Our Reference: SYD20/00855/02

Departments Reference: SSD-8571481

EXHIBITION OF EIS - TAFE NSW WESTERN SYDNEY CONSTRUCTION CENTRE OF EXCELLENCE HUB - 2-44 O'CONNELL STREET, KINGSWOOD

Attachment A

Notes:

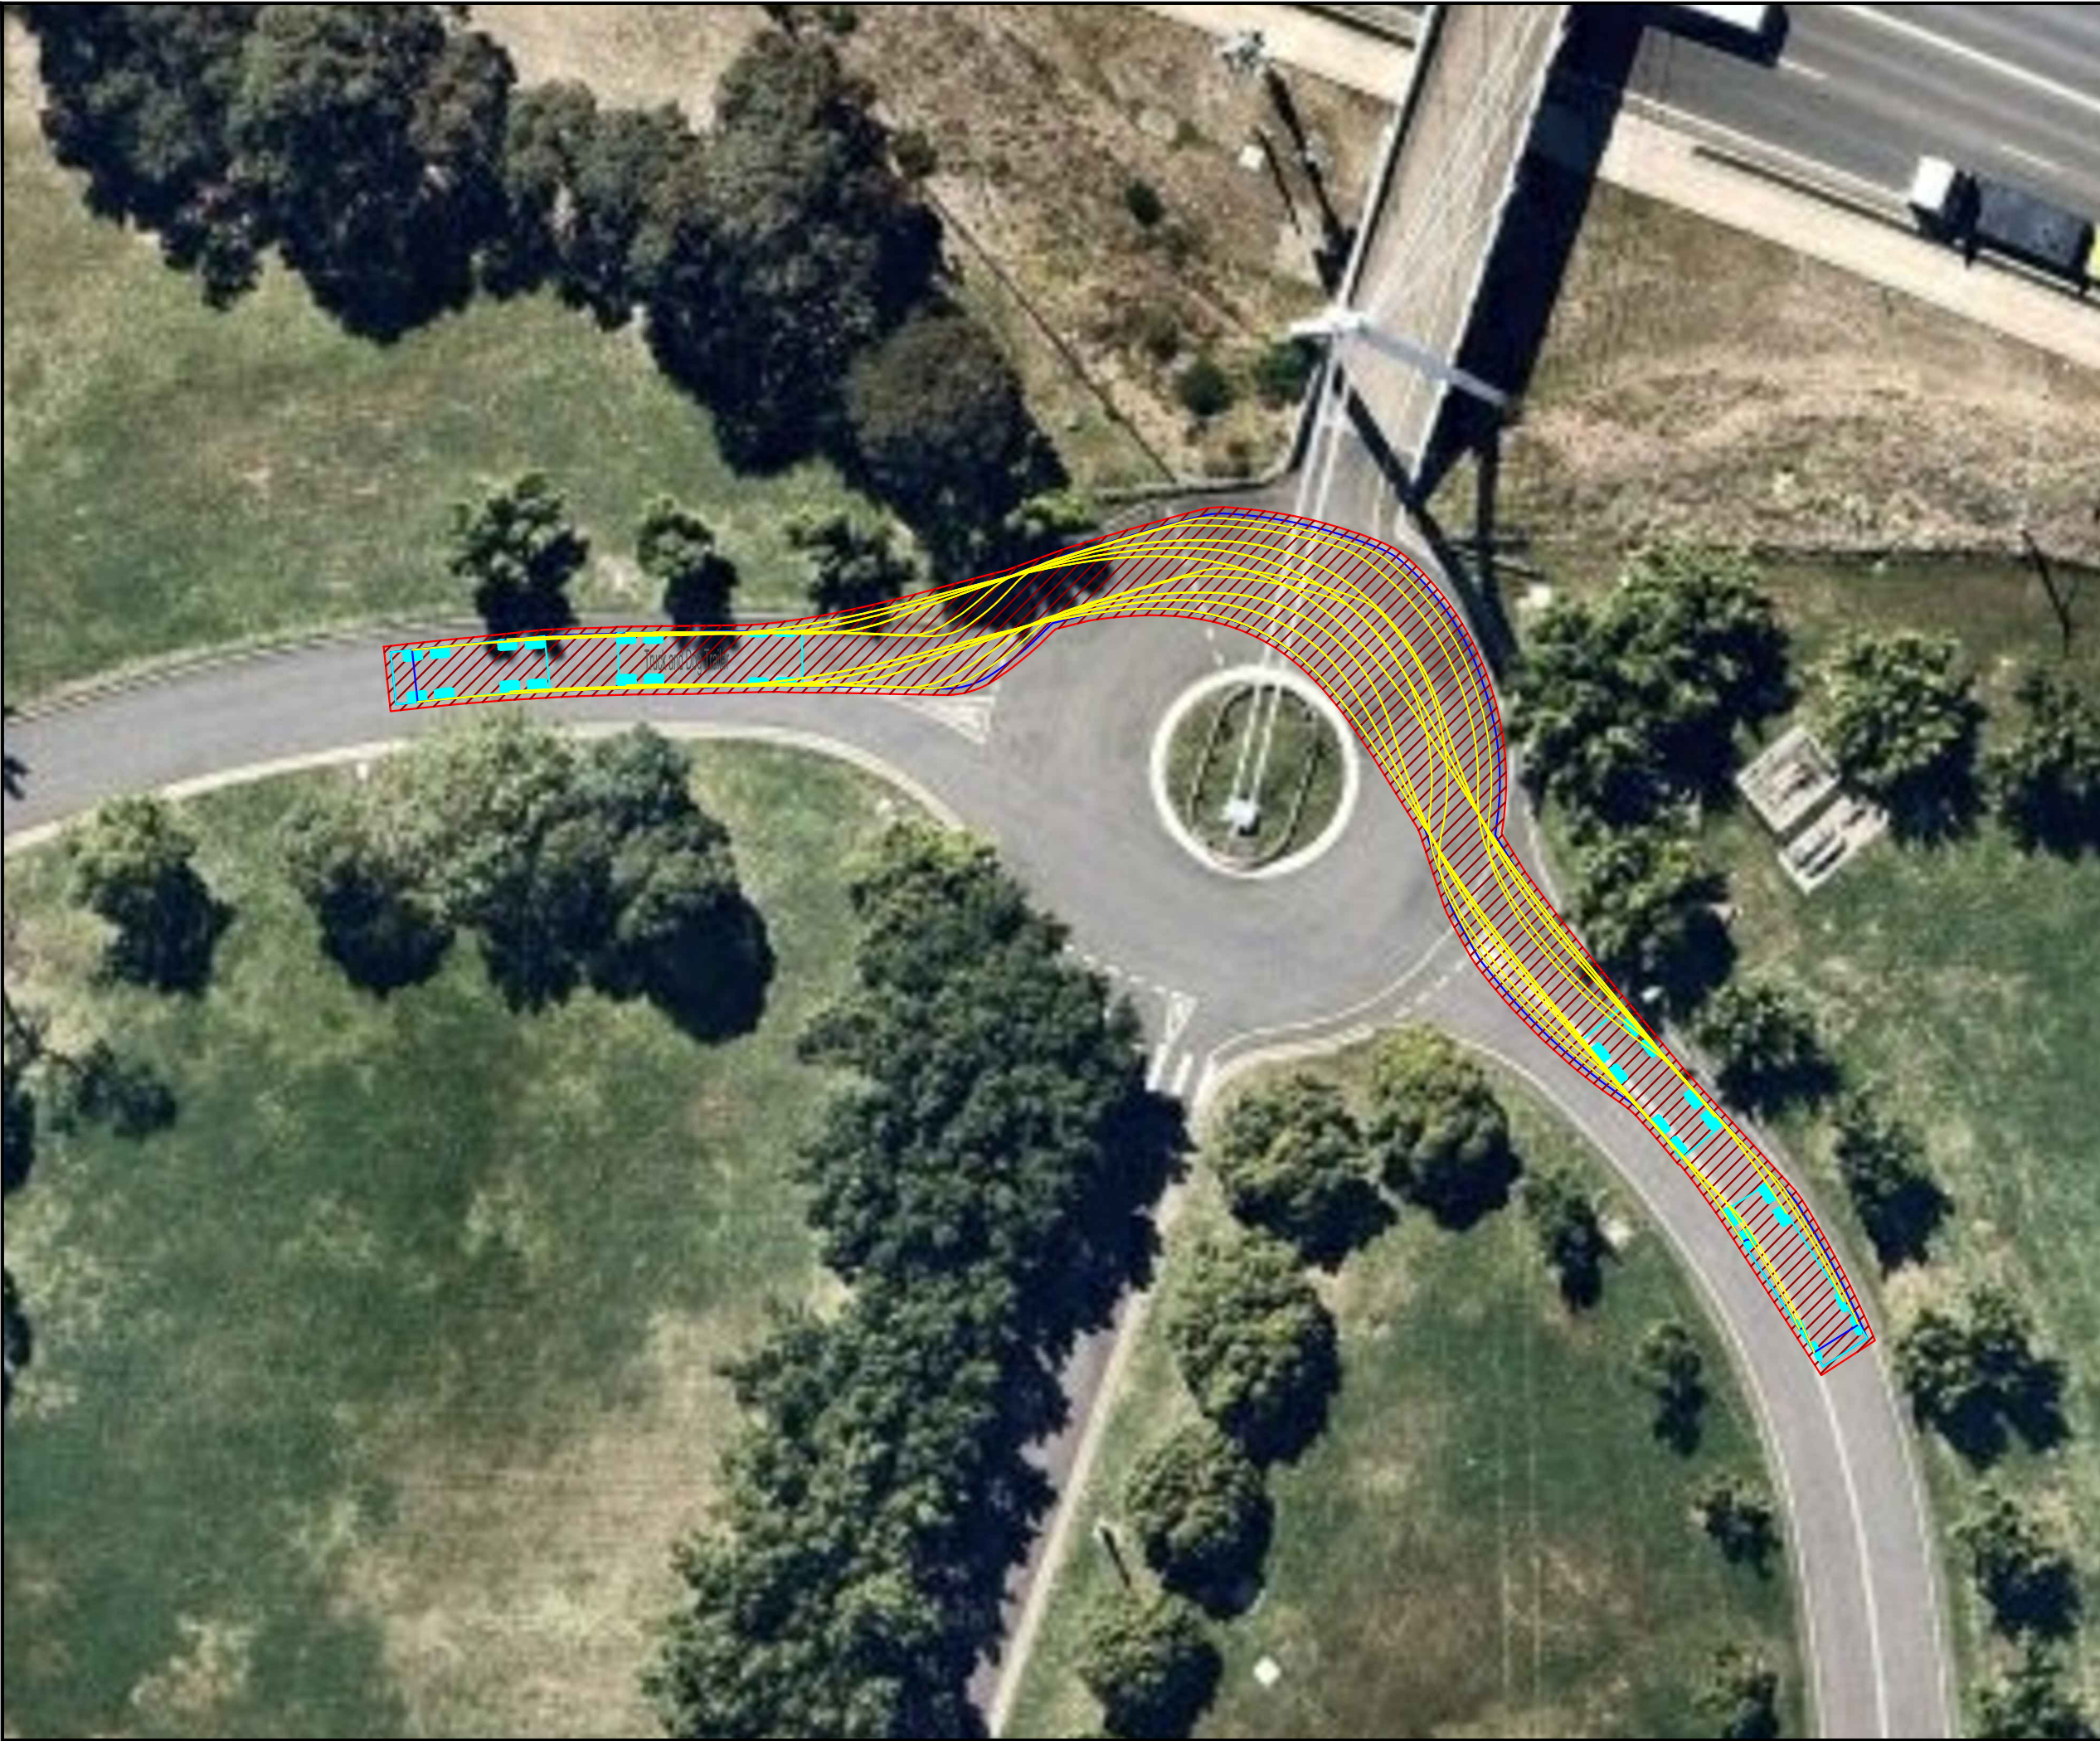
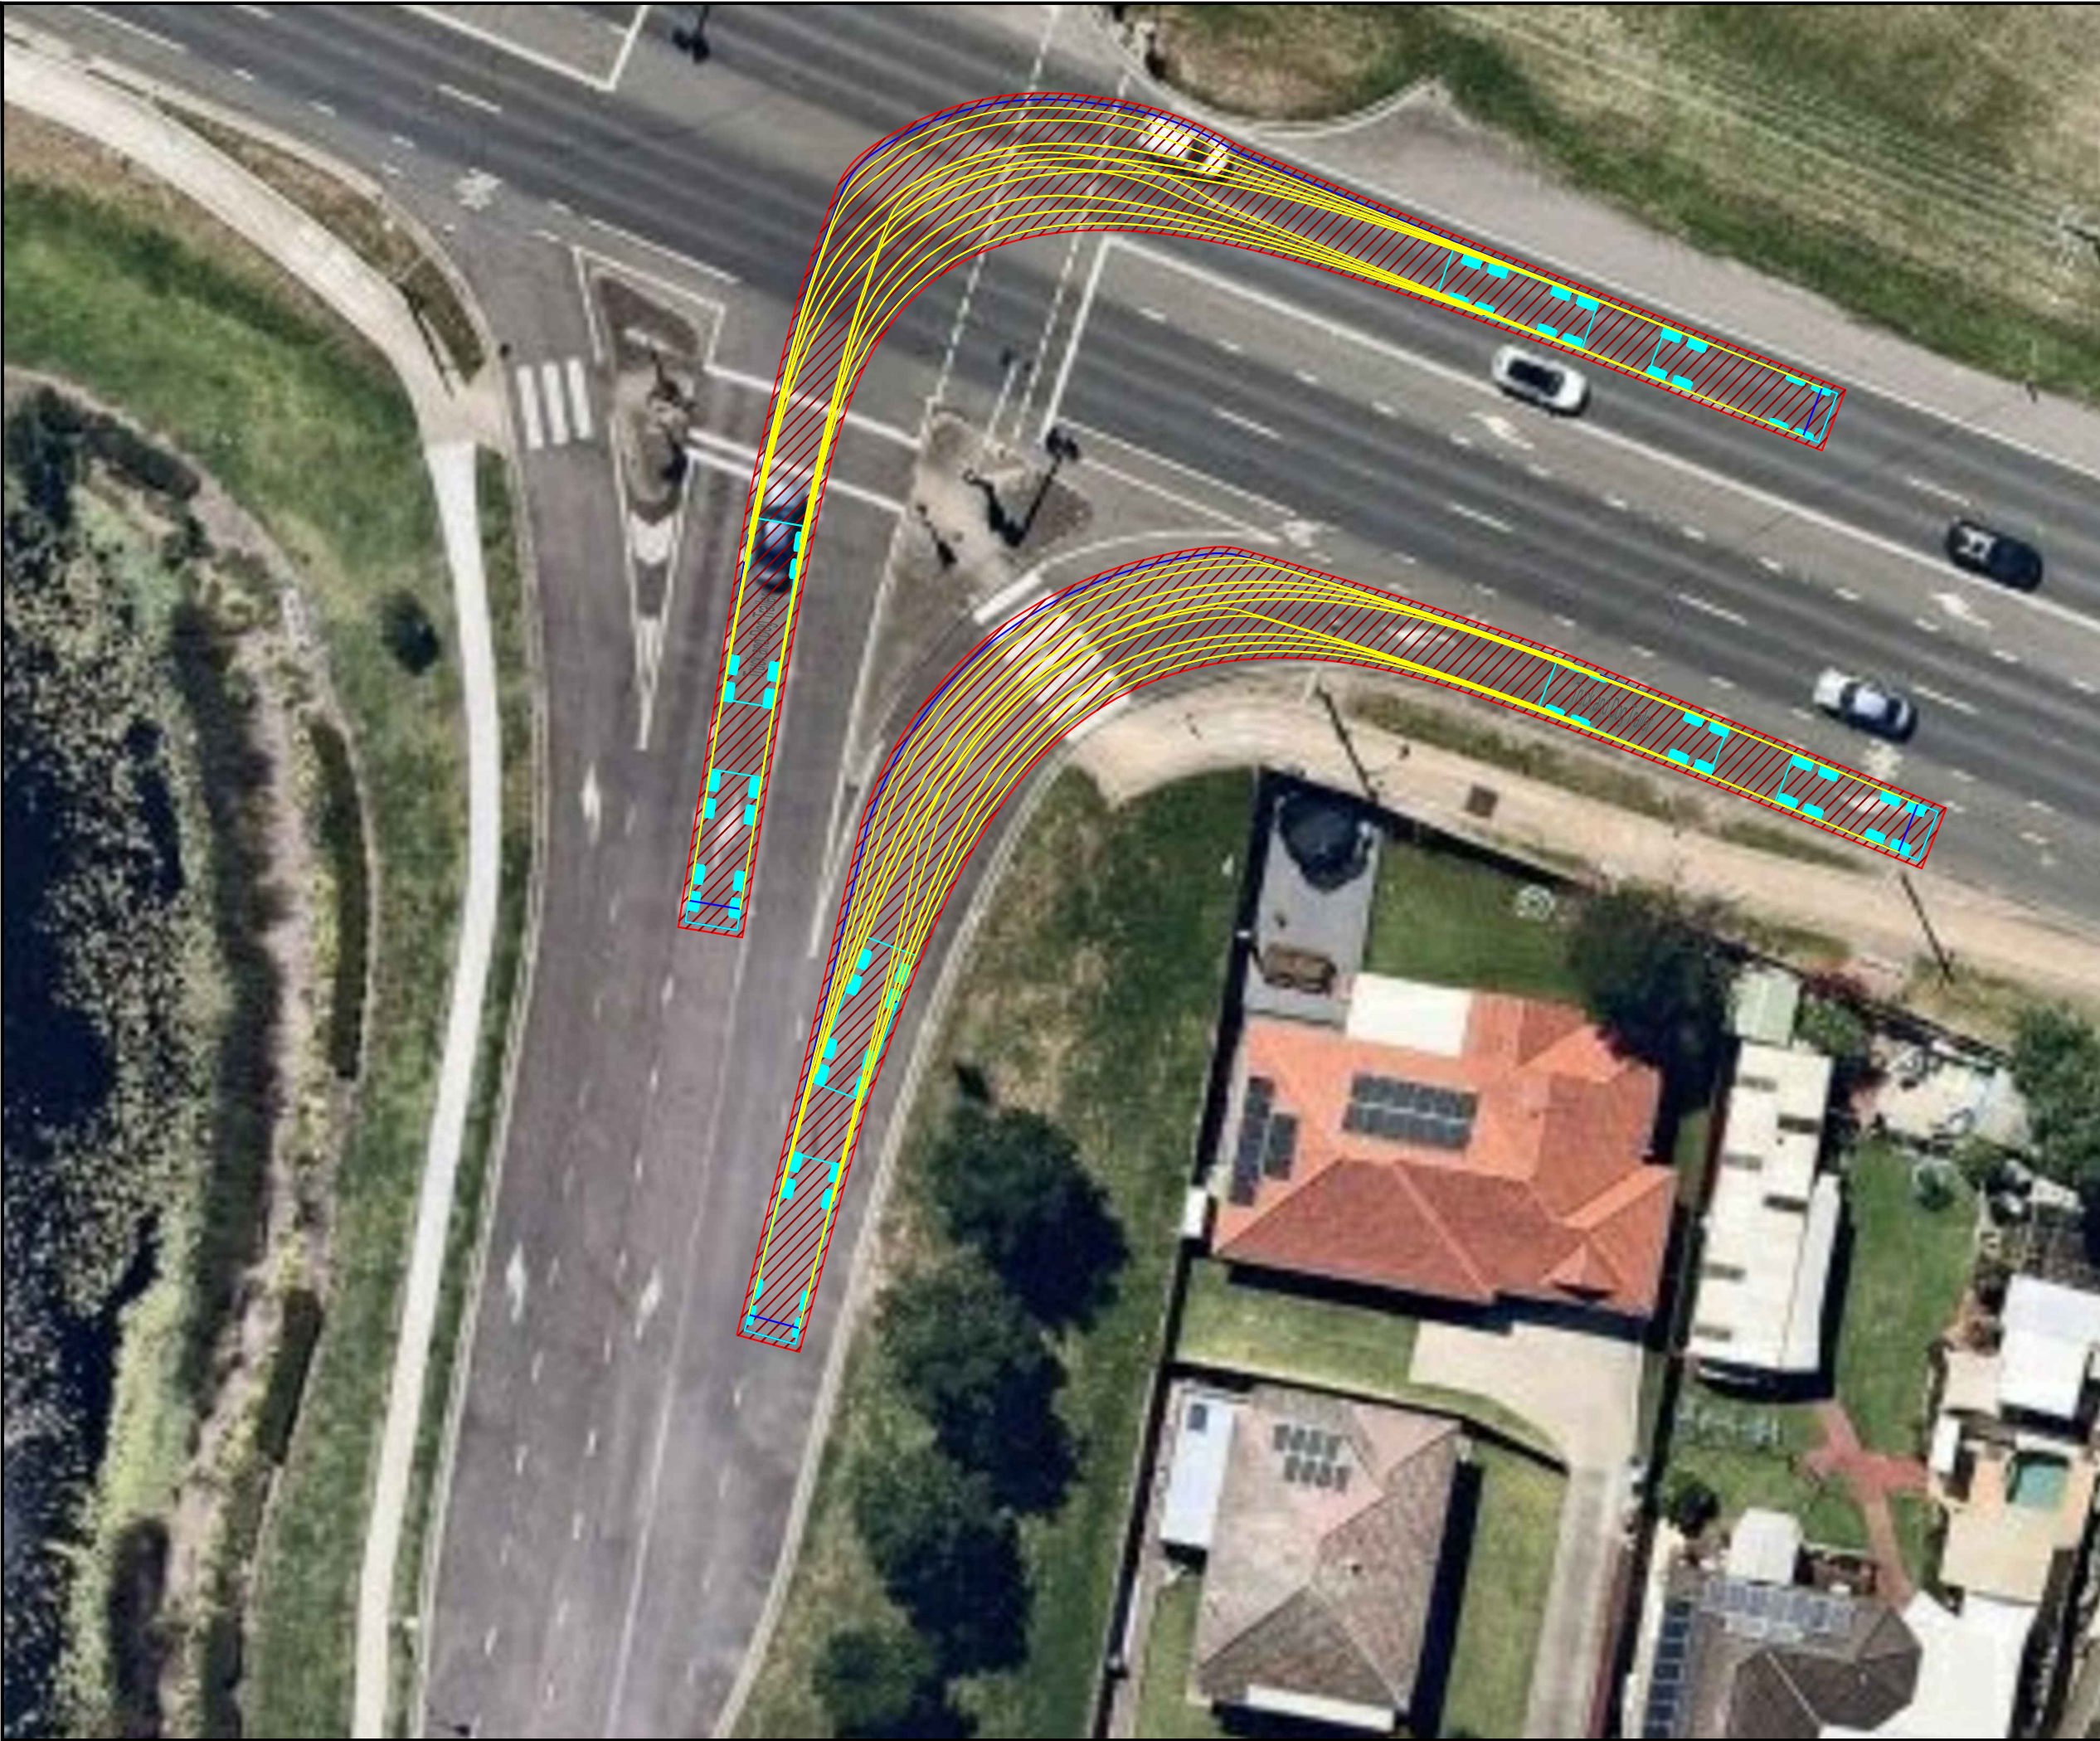
- a. Section 5.1.2: The truck routes will be using the GWH/Western Sydney University intersection. Modelling of this intersection is required to show the results of the intersection performance on each stage of work.
- b. Appendix C Loading Zone Swept Paths: Traffic Controller is recommended to ensure there is no conflict between construction trucks and vehicles / pedestrians using the carpark.

TfNSW requests the abovementioned information be addressed and the CTMP be updated to reflect the outcomes.
